**CITY OF ALBUQUERQUE  
PLANNING DEPARTMENT  
October 16, 2013  
DRB Comments**

**PROJECT # 1003928**

**APPLICATION # 13-70710**

**RE: Lots 2 & 7, Los Mochos Compound**

6' PORTION OF PRIVATE ACCESS  
EASEMENT VACATED BY THIS PLAT

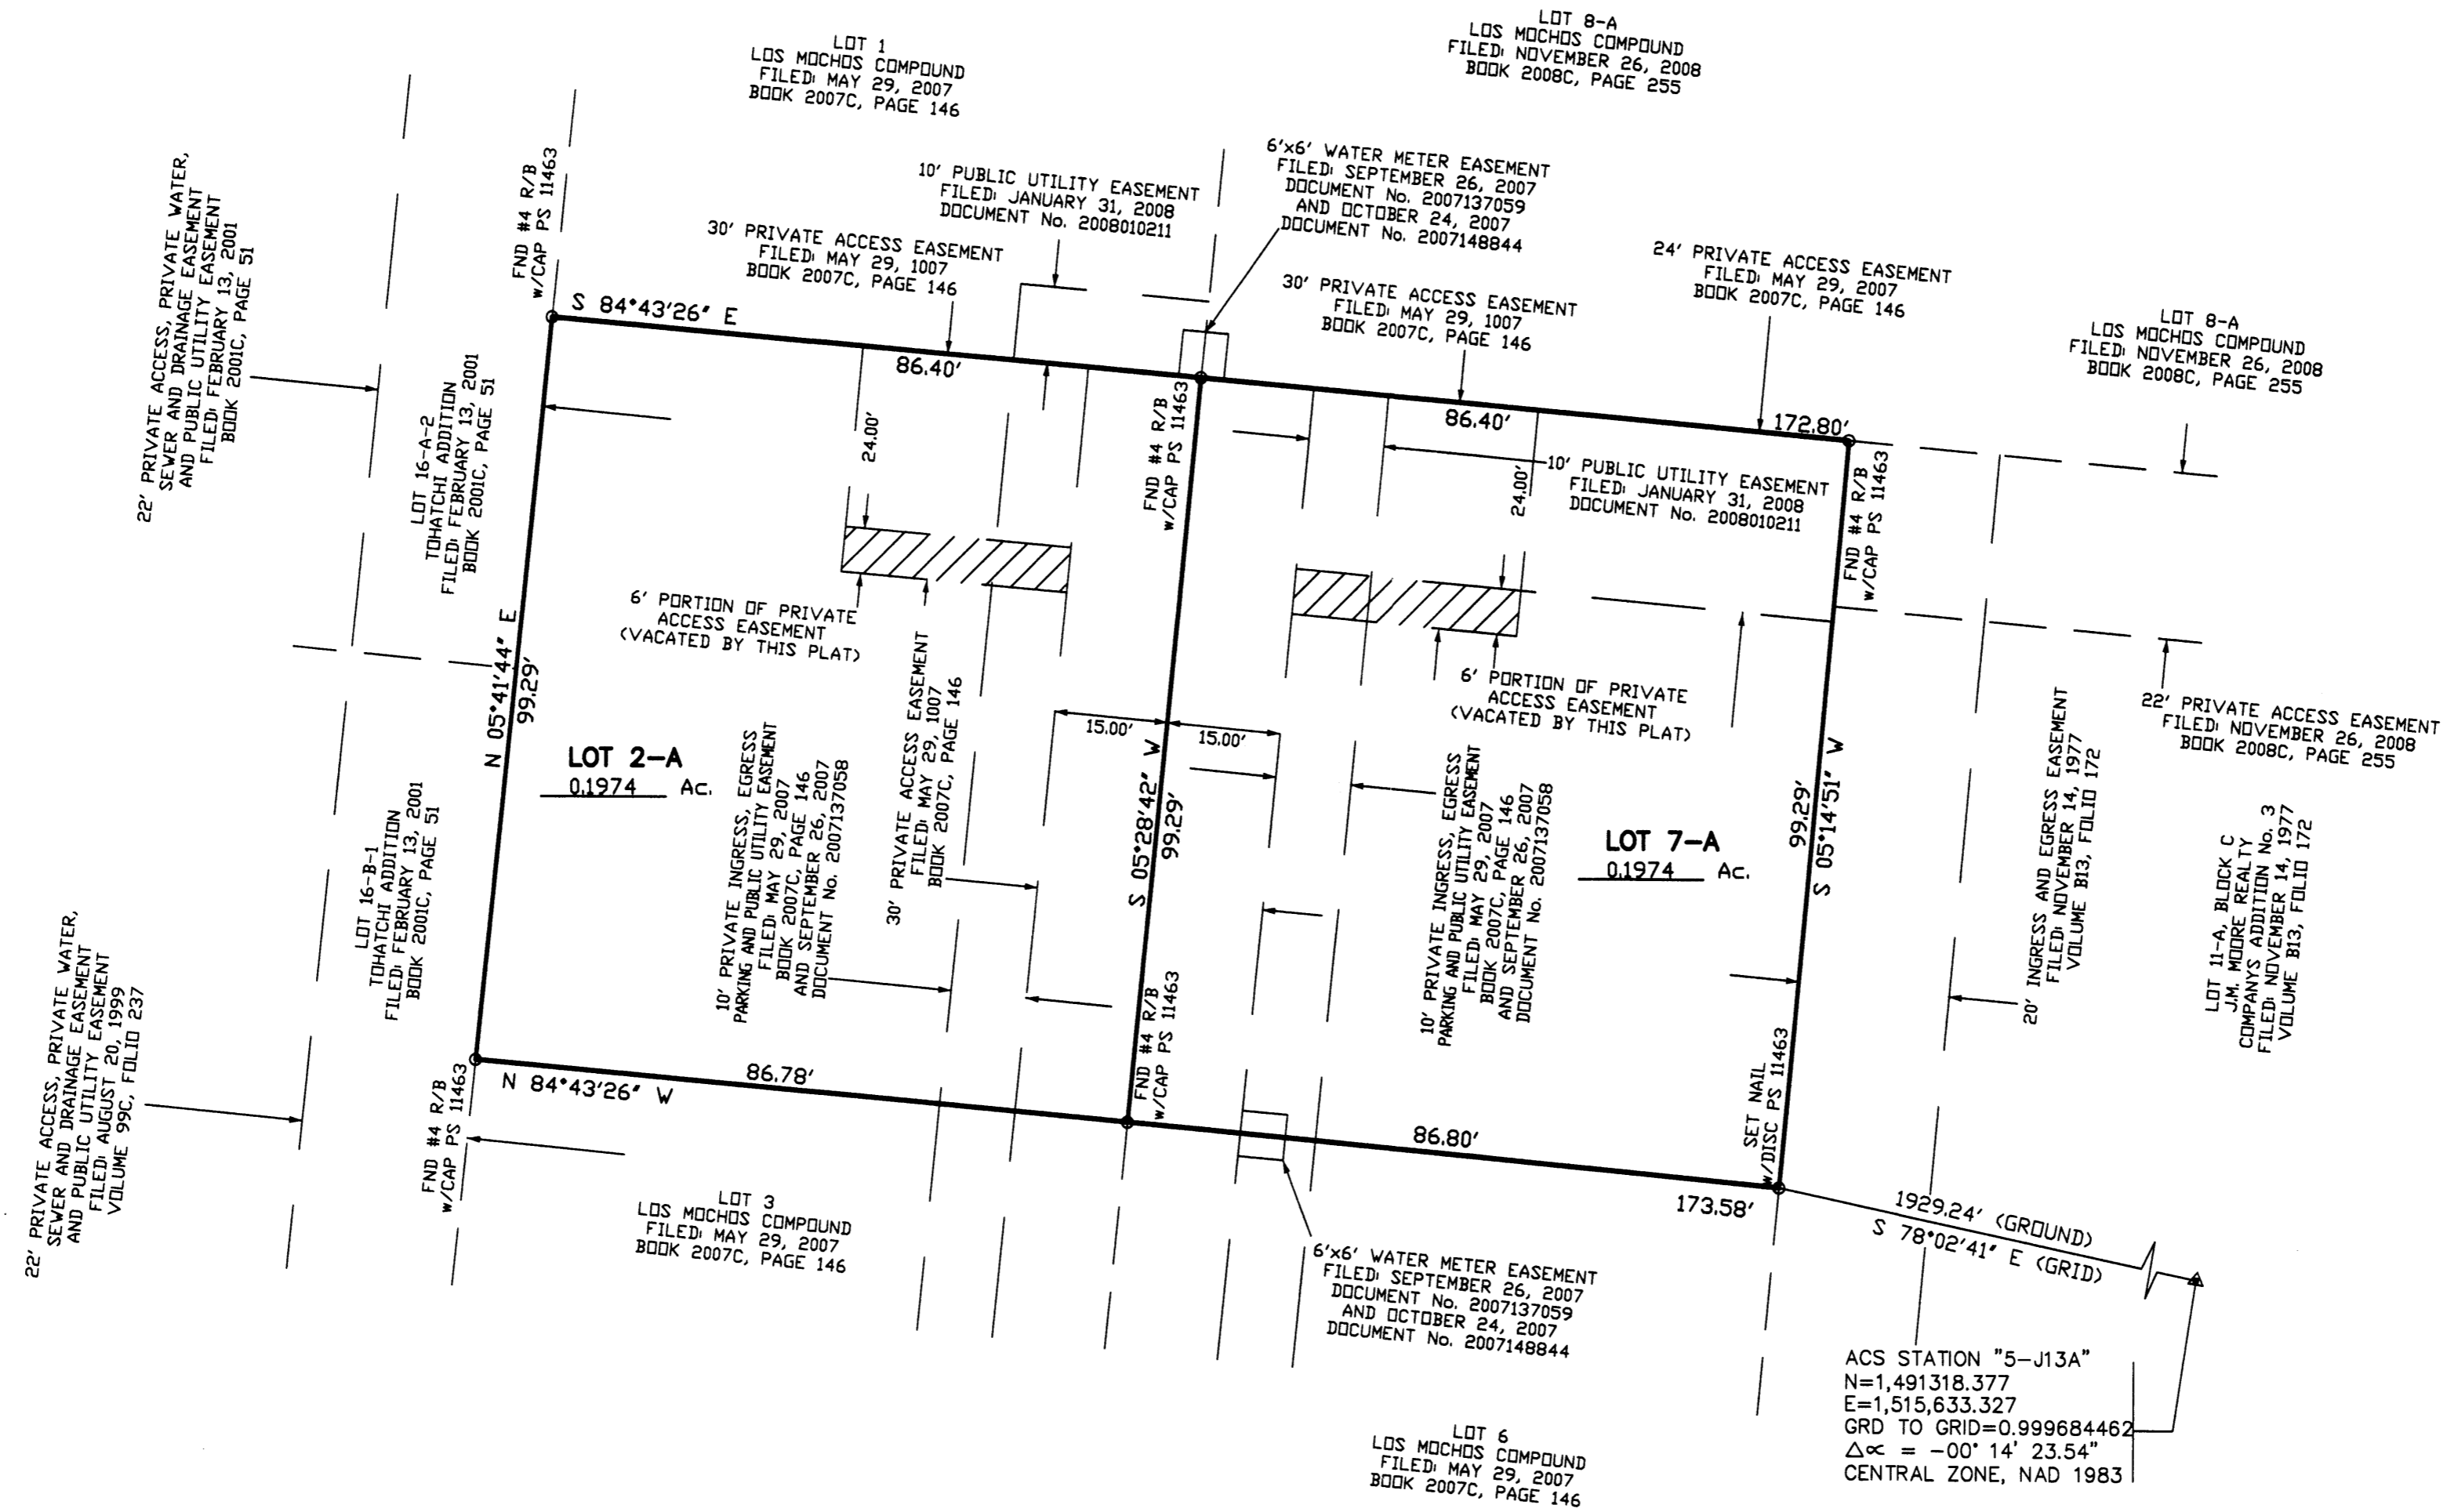
Vacation of a Private Easement requires approval of all benefited parties [§ 14-14-7-2(F)(1)]; this needs to be demonstrated by written approval from all the property owners in Los Mochos Compound. Additionally, written concurrence would be needed from the Solid Waste Department as well as the Fire Department.

One of the purposes of easements (and Rights of Way) is to allow maintenance of the respective facilities – this inherently requires additional width for machinery, finishing and repair. Refer to comments from Transportation Development, but it generally requires a minimum 4 feet beyond the width of a street for its maintenance.
